From: Harry Chalk
Sent: 30 July 2026 12:11
To: 'Office' [REDACTED]
Cc: Daniel Vick <Daniel.Vick@arun.gov.uk>
Subject: RE: FG/47/26/PD - The Haystack

Subject: FG/47/26/PD - The Haystack

SECOND FLOOR PLAN | PROPOSED

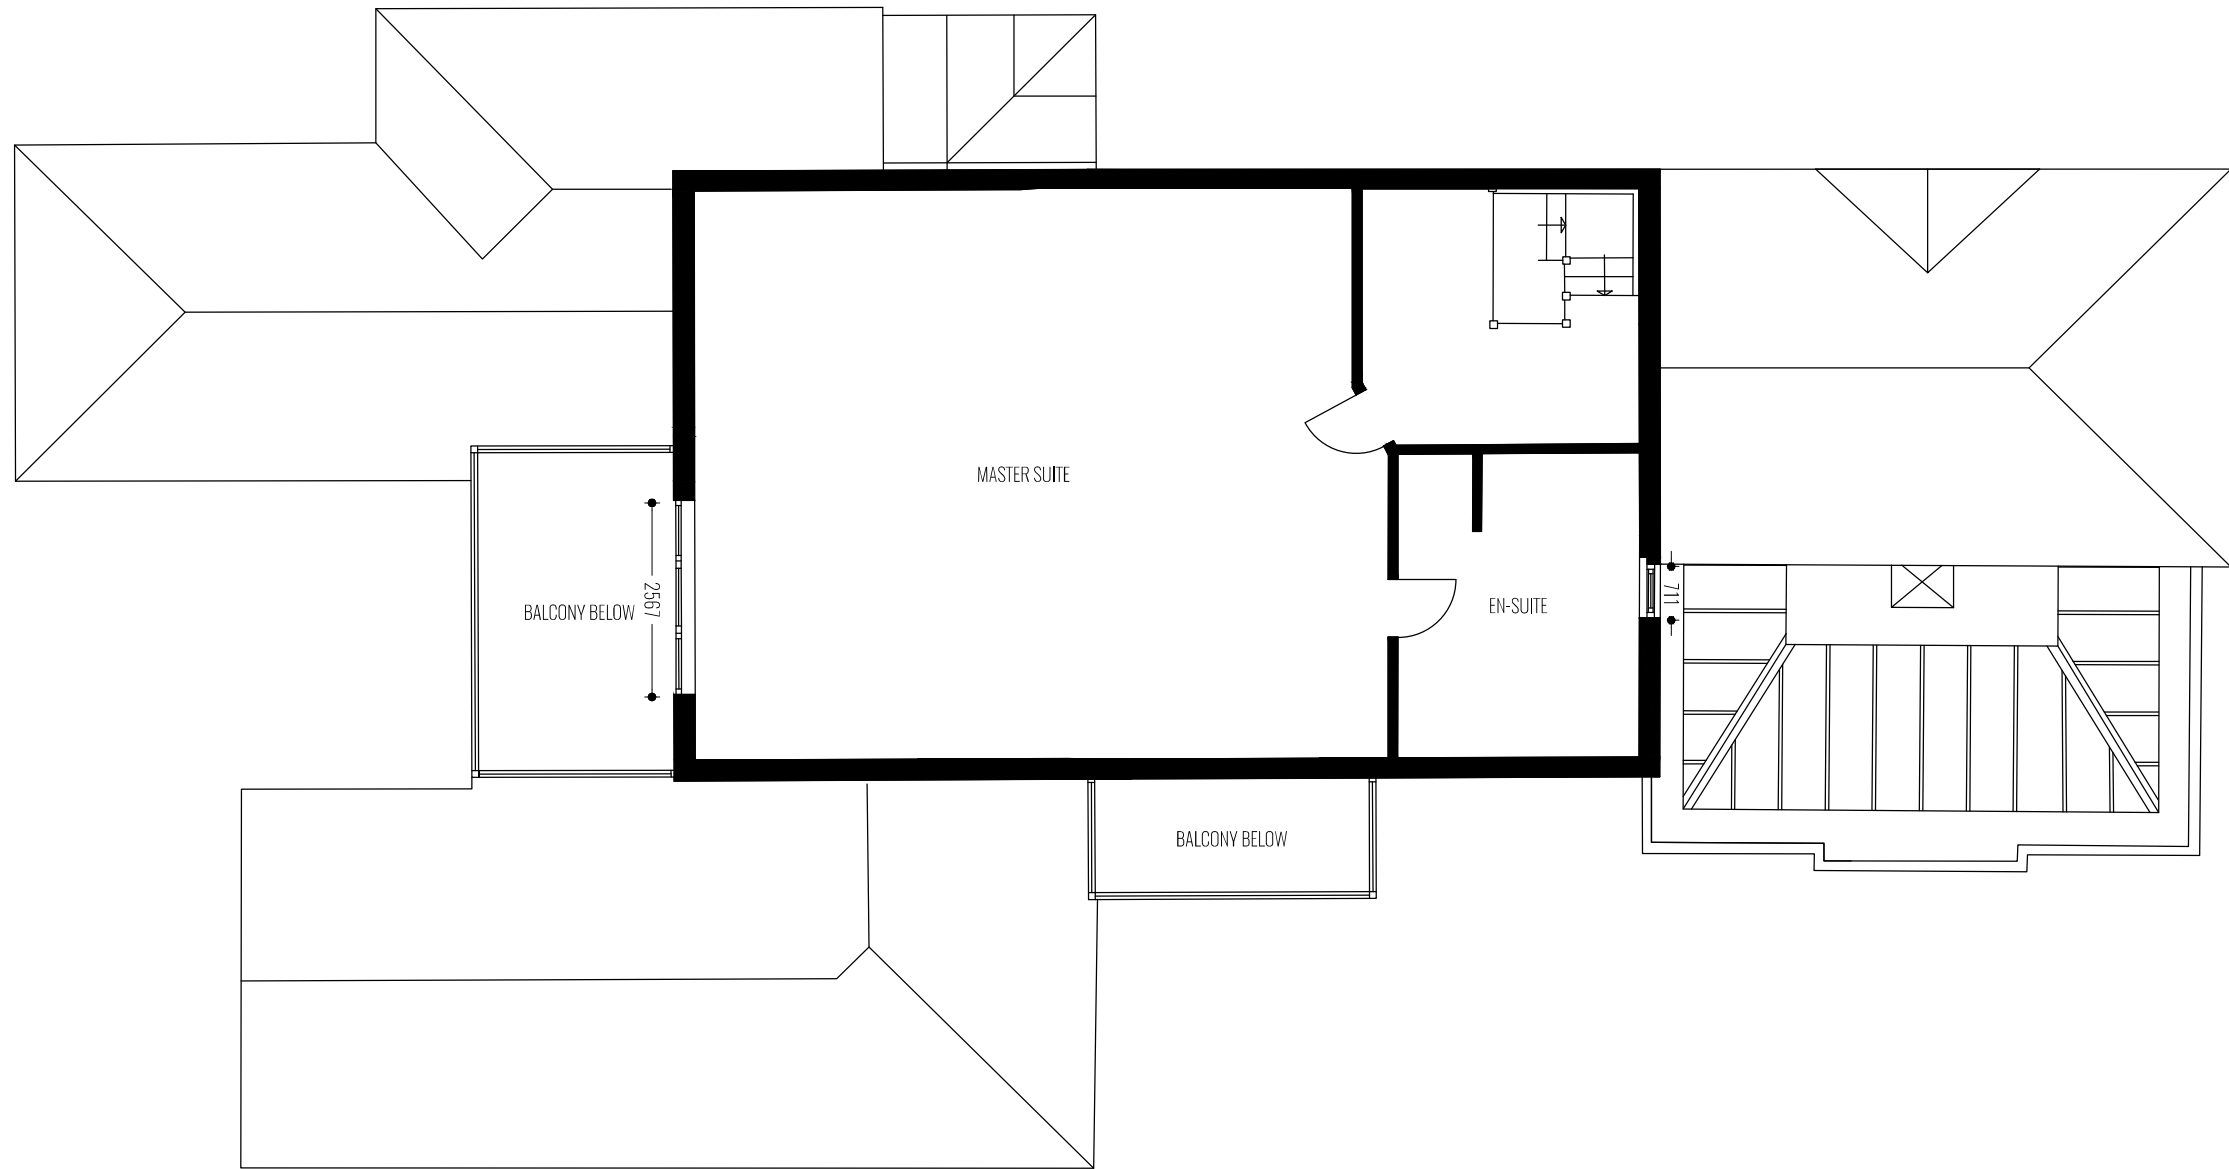
Since my prior email, we have also had time to continue the assessment of the application and review the external appearance of the building, including its principal elevation. We have concluded that the proposed development would result in a visually jarring and unbalanced appearance that is not sympathetic to the building, particularly regarding the south and west elevations, in conflict with the aims Paragraph 131 of the NPPF. As such, we will be objecting to the prior approval in due course on Condition AA.2(((3)a)ii).

To address this issue I have amended to reflect this previous extension with the proposed plans so that the part of the roof associated with the previous extension is not extended or raised any further. The proposed additional storey will therefore be limited to the remaining original roof area that formed the principal part of the dwellinghouse.
